PROJECT NO. 1002156	APPLICATION NO. 02 DRB - C1838
PROJECT NAME EASTERN ADDN	
APPLICANT / AGENT Liciswela Martinez	PHONE NO. 247-2616
ZONE ATLAS PAGE L-14	DATE SUBMITTED 12-3-02

PROJECT NO. 100 2156	APPLICATION NO. 02 DRB - 01838
PROJECT NAME EASTERN ADDN	
EPC APPLICATION NO.	
APPLICANT / AGENT Consuelo MARTINEZ	PHONE NO. 247-2616
ZONE ATLAS PAGE L-14	
ONE STOP COMMENT FORM LOG

DRB CASE NO/PROJECT NO: 1002156

14. **Project # 1002156**
02DRB-01260 Minor-Sketch Plat or Plan

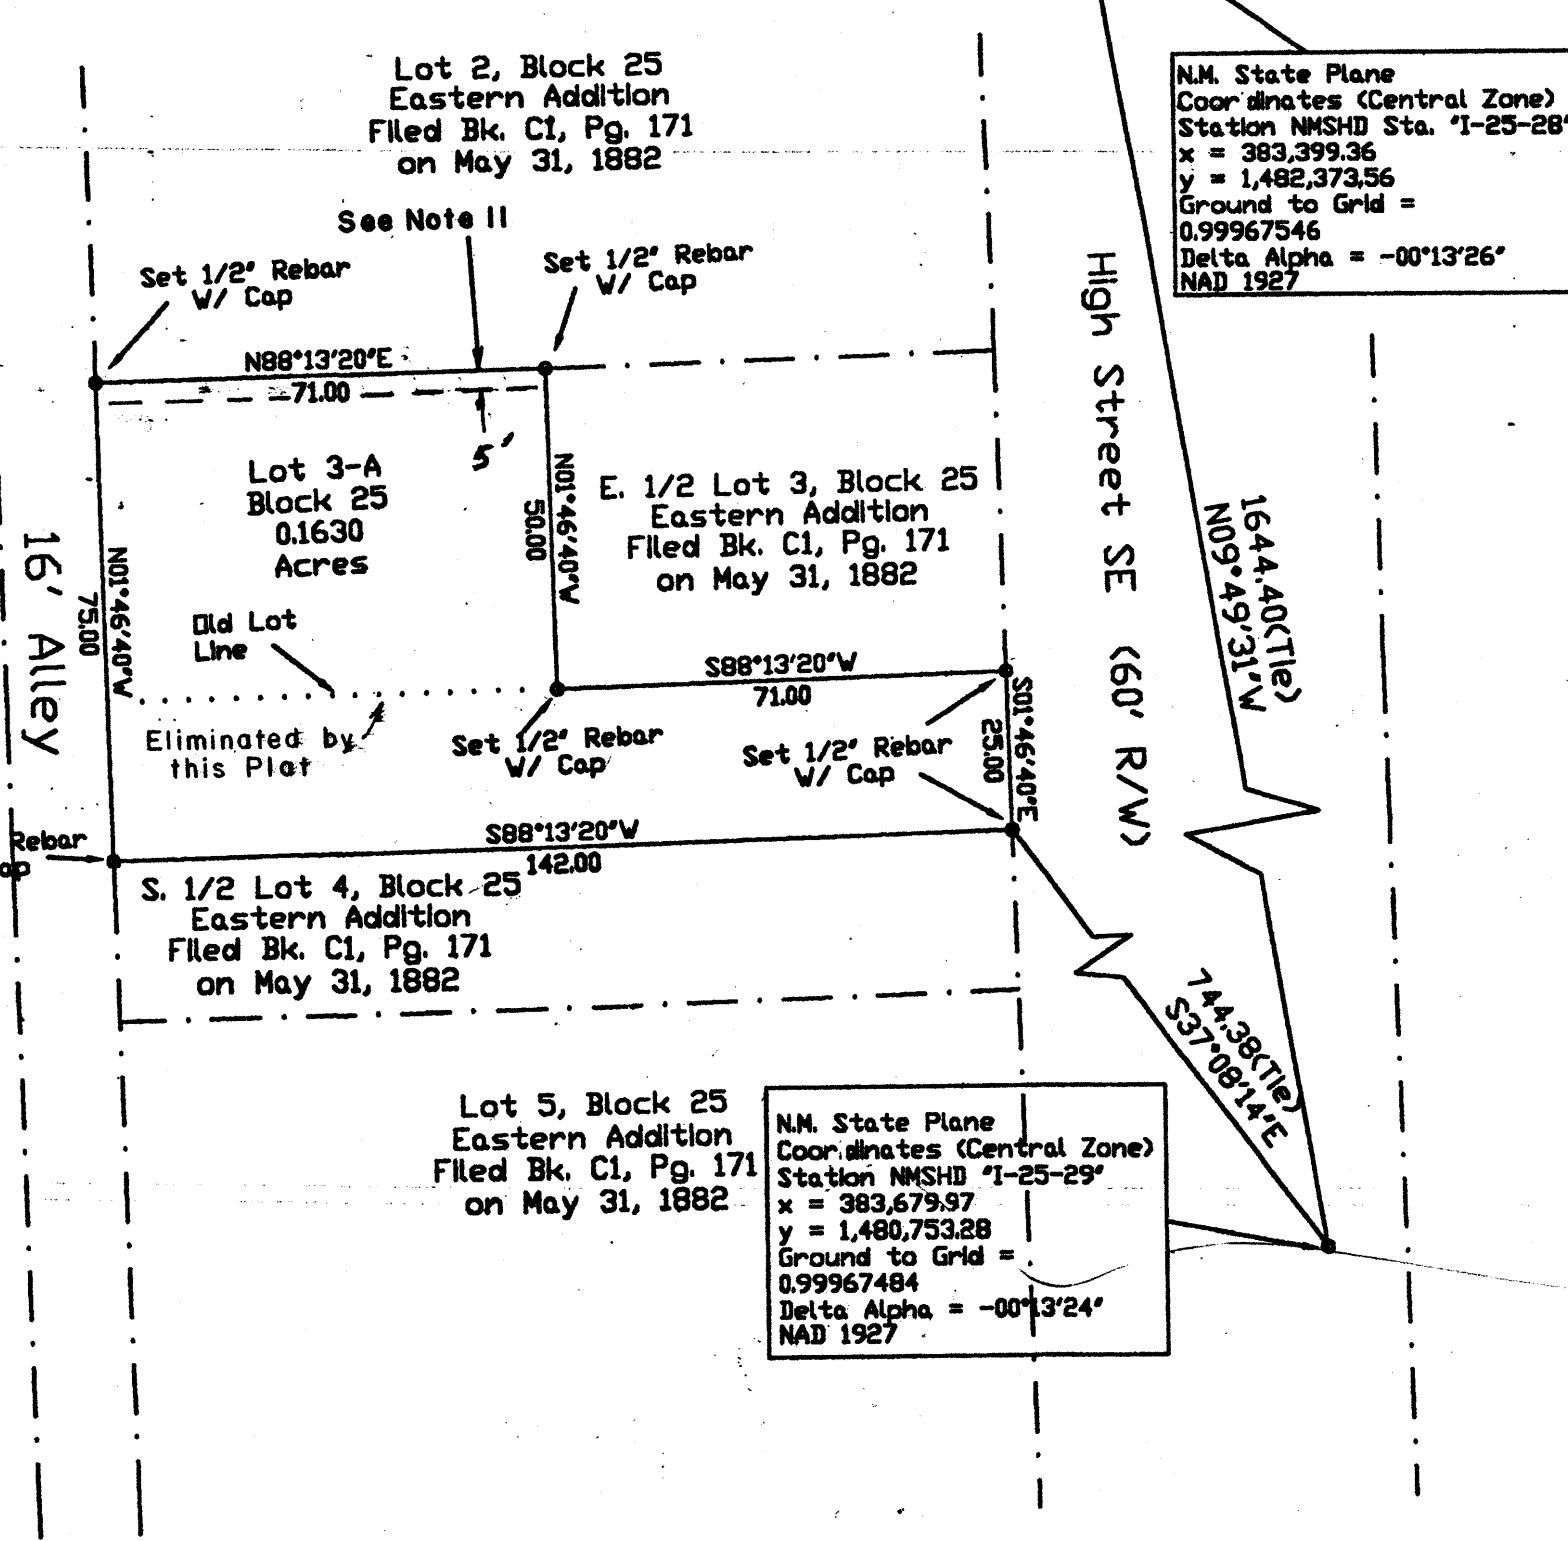
TRANSPORTATION DEV (505) 924-3990		
PLANS DISAPPROVED	DATE	DATE
PLANS APPROVED <i>RD</i>	DATE 12-05-02	DATE
ENTIRE Lot 25 needs COMMENTS: to be PLATTED. (You are platting only portions of this lot.) OK (1882)

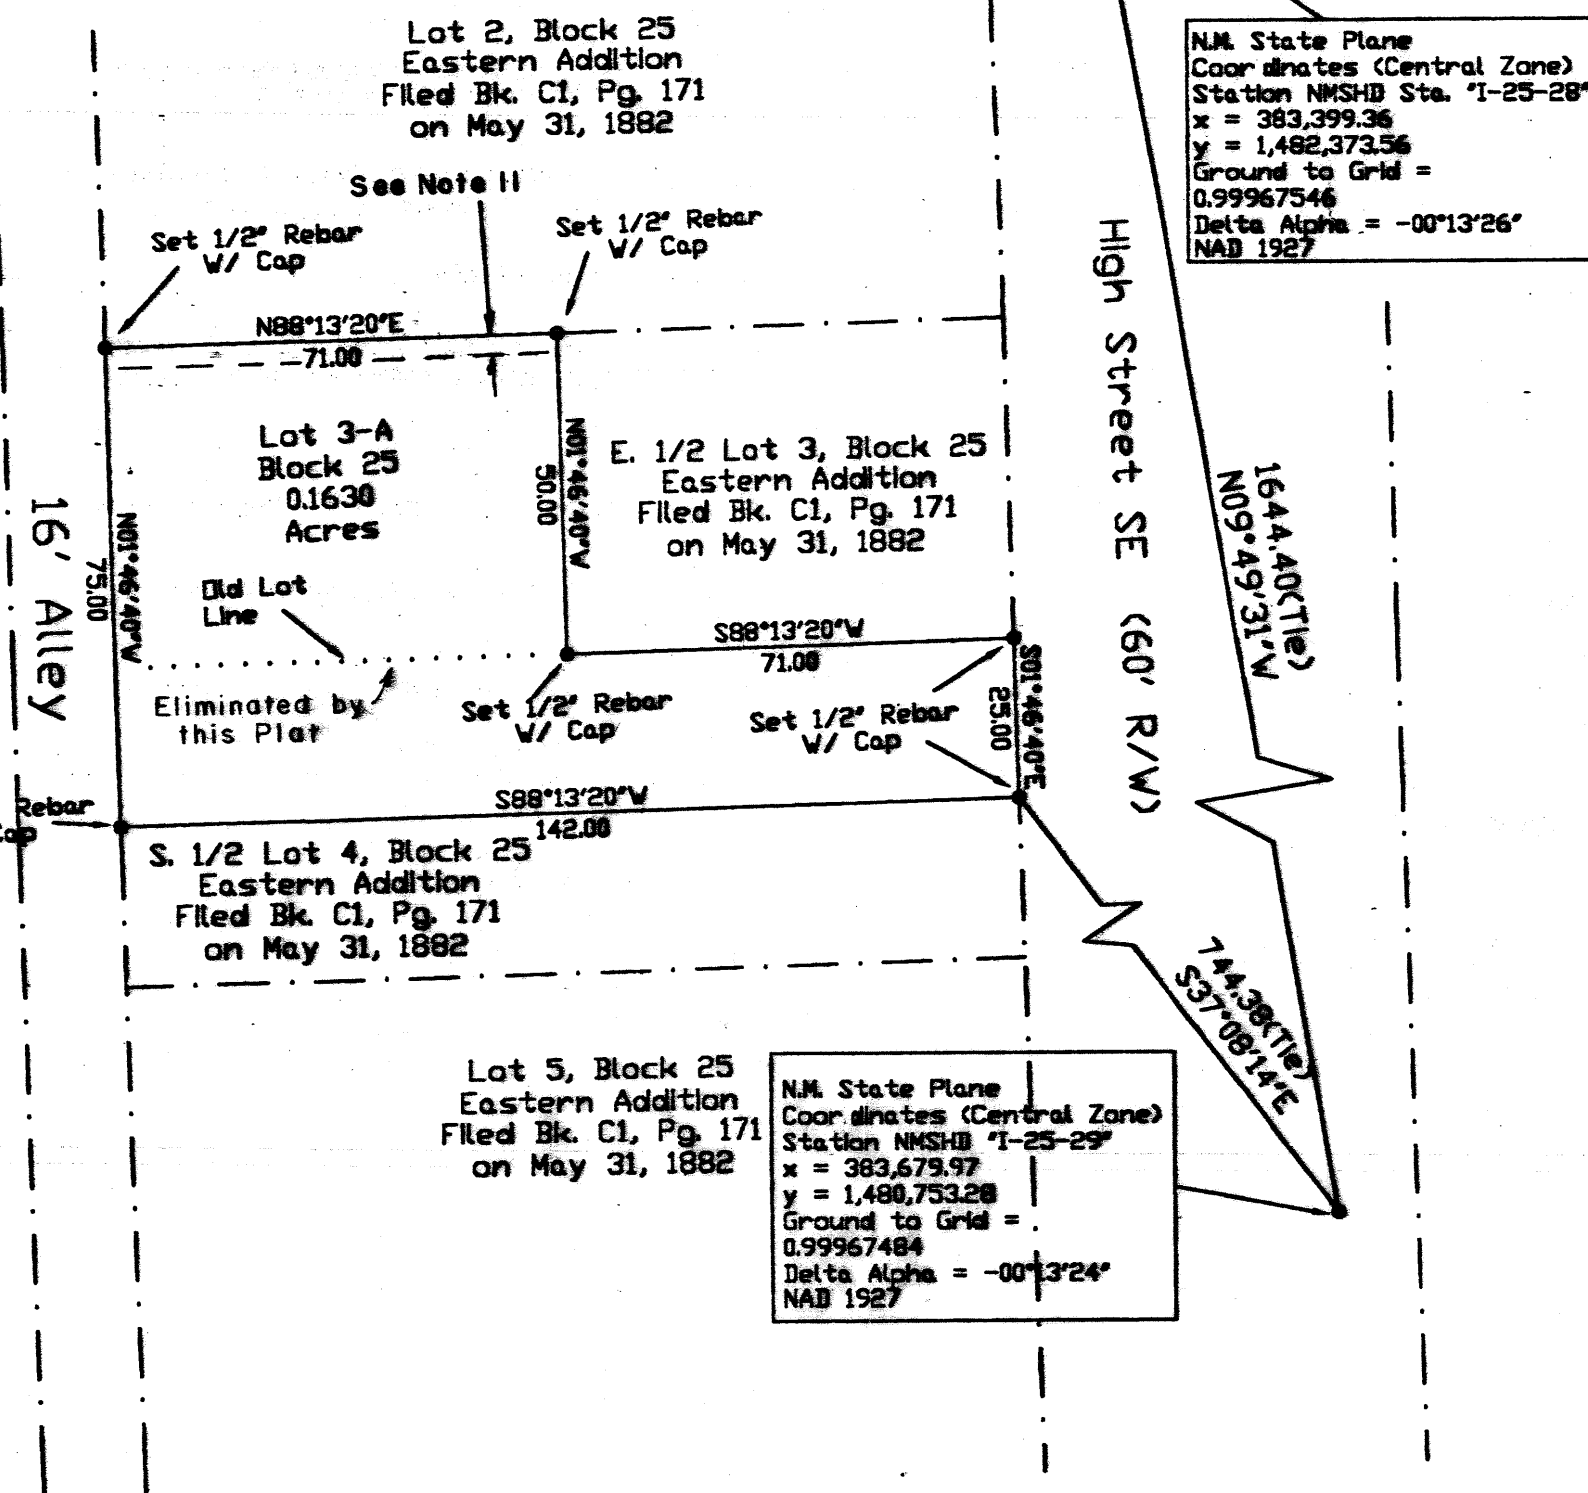
- ① Need to field locate sewer service for E 1/2 Lot 3 and provide easement across Lot 3-A to alley
- ② Must show that separate water/sewer accounts exist for both houses.
